Case Officer: Lewis Knox

Applicant: Sandra & Patrick Clacy

Proposal: Single storey rear extension

Proposed North Elevation  
Scale: 1:100

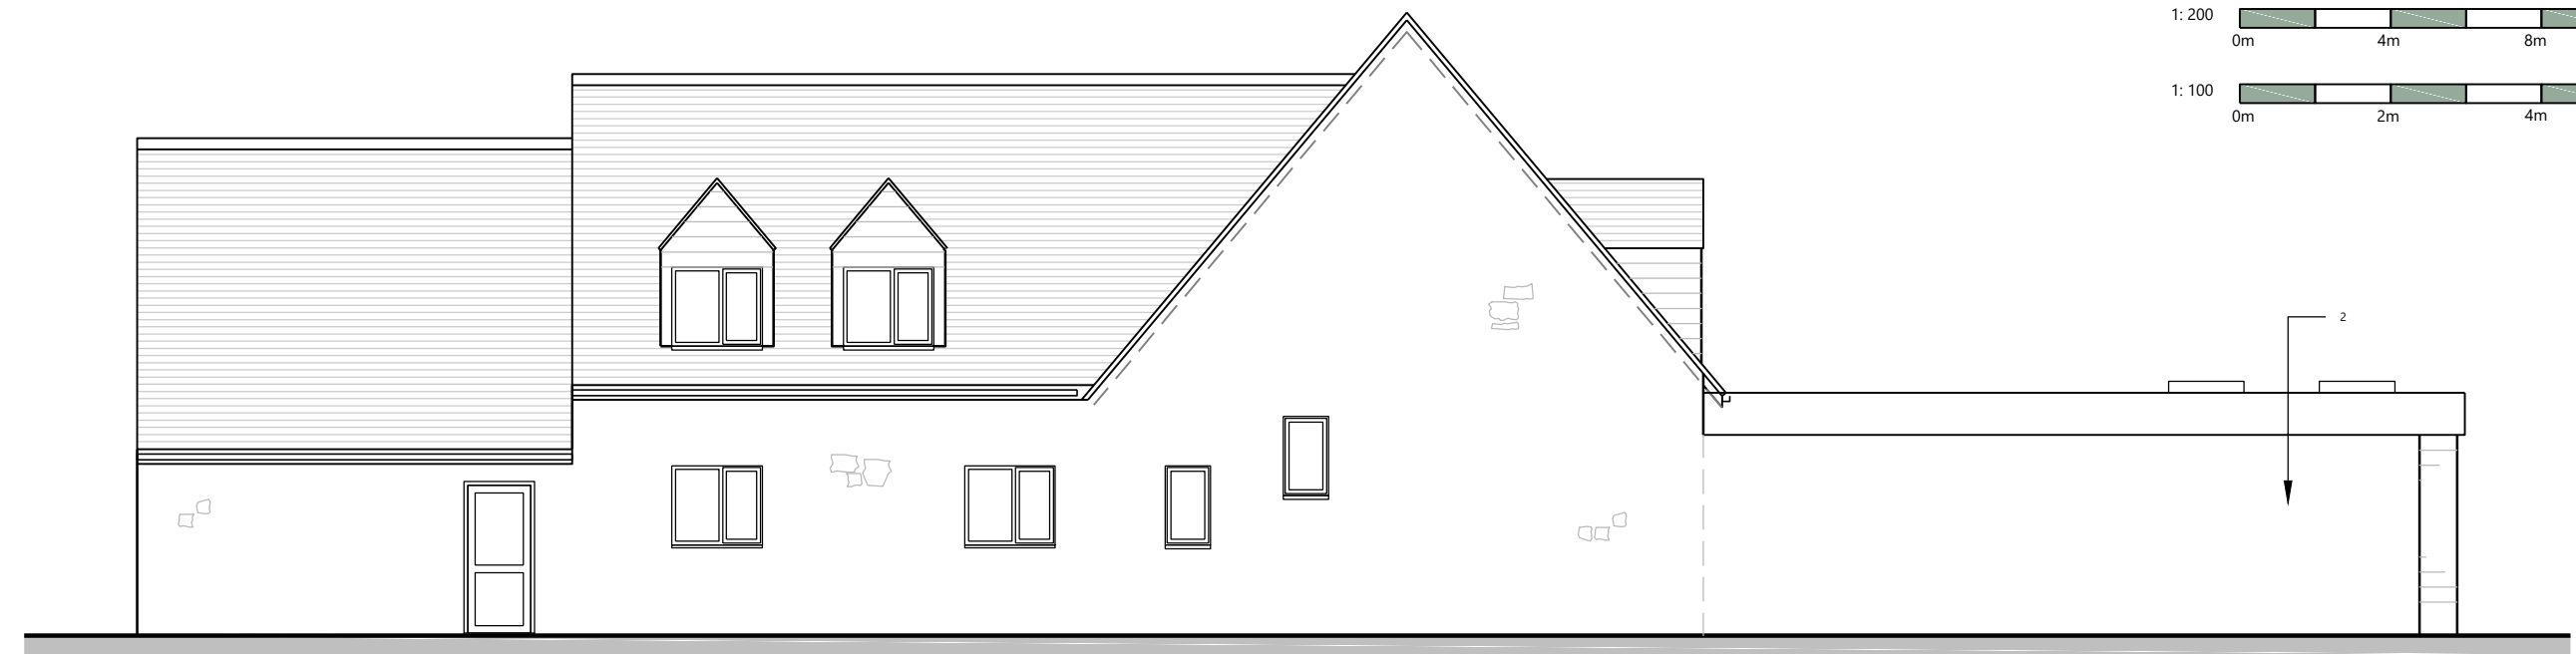
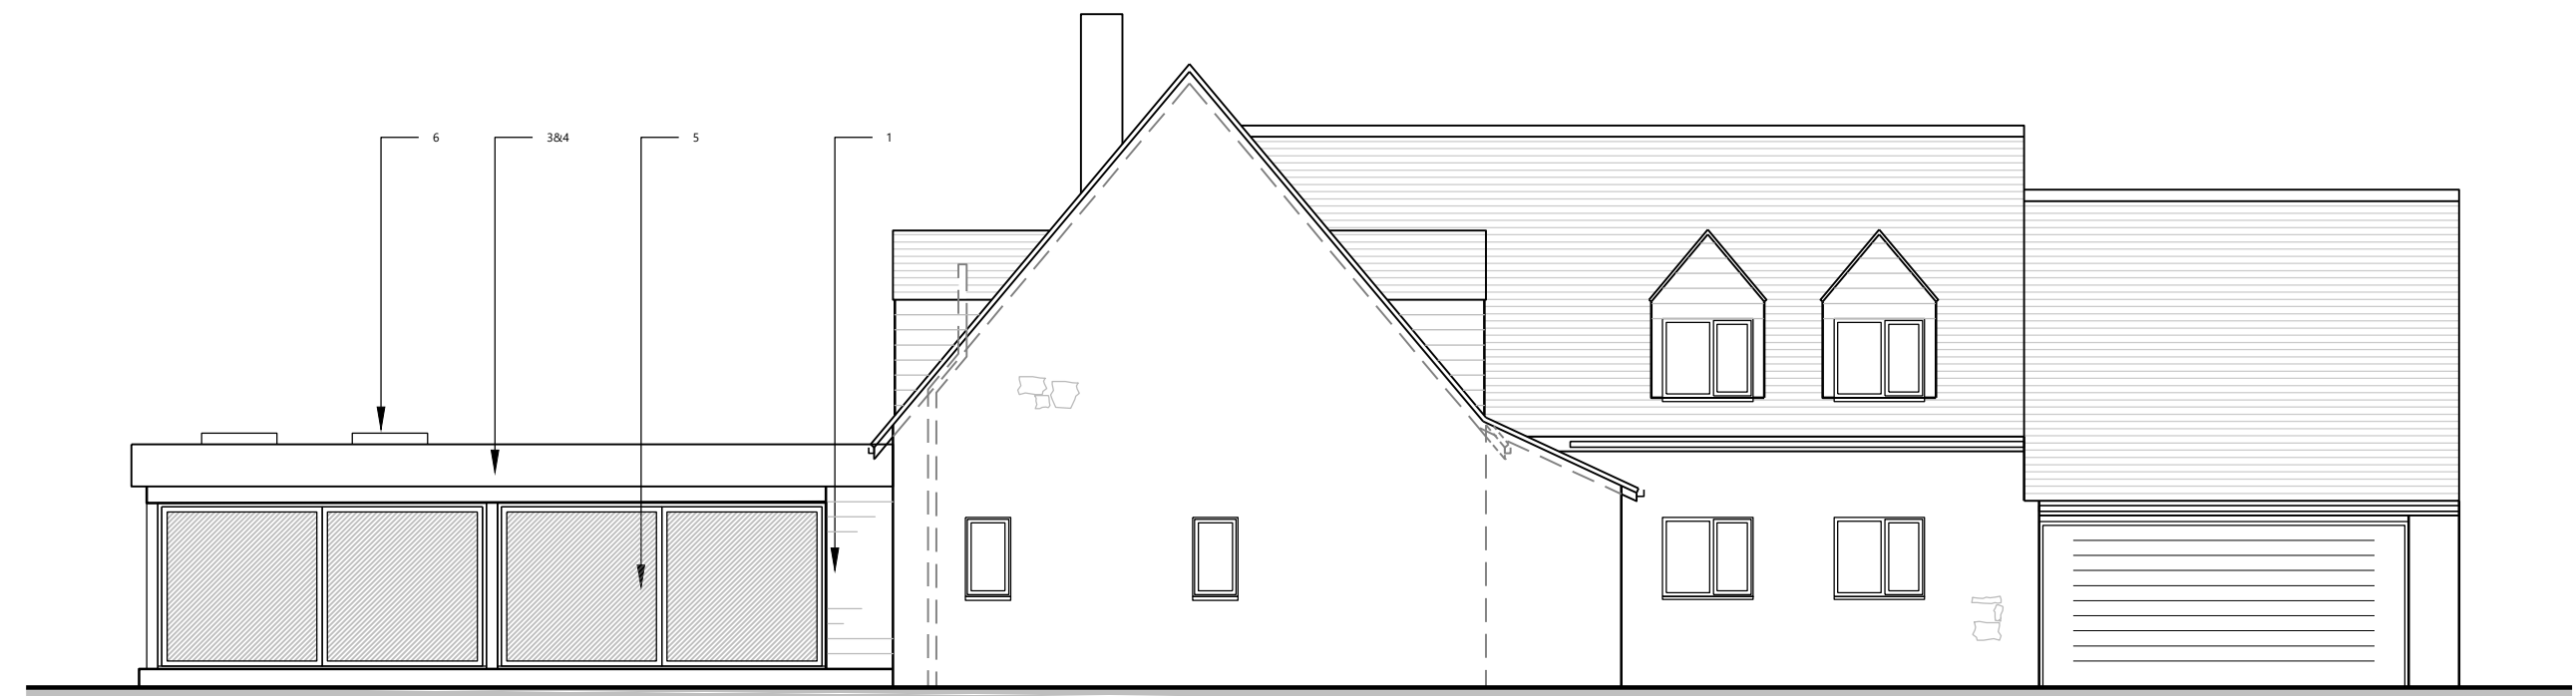
- The proposed single storey extension would be to the rear of the dwelling and would not be readily visible from the public domain and would not have a significant impact on the character and appearance of the streetscene.
- The extension would be relatively large in depth but its overall scale would be appropriately subservient to the original dwelling by virtue of the relatively low level flat roof.
- Whilst large in size the extension would not appear cramped within its setting given that the application dwelling benefits from large plot to the rear.

- Extensions such as this are typical of residential dwellings and so the development would not appear alien within its setting. Other neighbours within the vicinity have also completed similar single storey rear extensions.
- The extension would be largely glazed with some cladding and some render. Whilst cladding is not a typical material of the district, it is considered to be acceptable in this instance as it would not be readily visible from outside of the site and the site itself is not located within an area of special character.
- The render would be on the blank elevation facing north towards the neighbouring property. Whilst it would be preferable to see a continuation of the stone, the lack of views to the elevation means the render would have little impact on the character of the area.

- The proposed extension would be in close proximity to the boundary with the neighbouring dwelling to the north, however given the large plot sizes at the site and neighbouring dwelling, the extension would be set away from the main dwelling at the neighbouring property. This would ensure that the development would not impact on the amenity of the occupants in terms of loss of light, loss of outlook or overbearing.

- Given the relatively low height of the extension, and the boundary treatments between the dwellings it is not considered that the development would overbear on the neighbouring garden.

- The development would be significantly set away from the neighbouring dwellings to the south.
- There would be no openings which would face towards the neighbour to the north and so levels of privacy would be retained between the properties.

- There would be a large amount of glazing which would face towards the boundary with the southern neighbours but given the boundary treatments and the ground floor nature of the openings it is not considered that the glazing would result in harmful overlooking into these neighbouring properties.
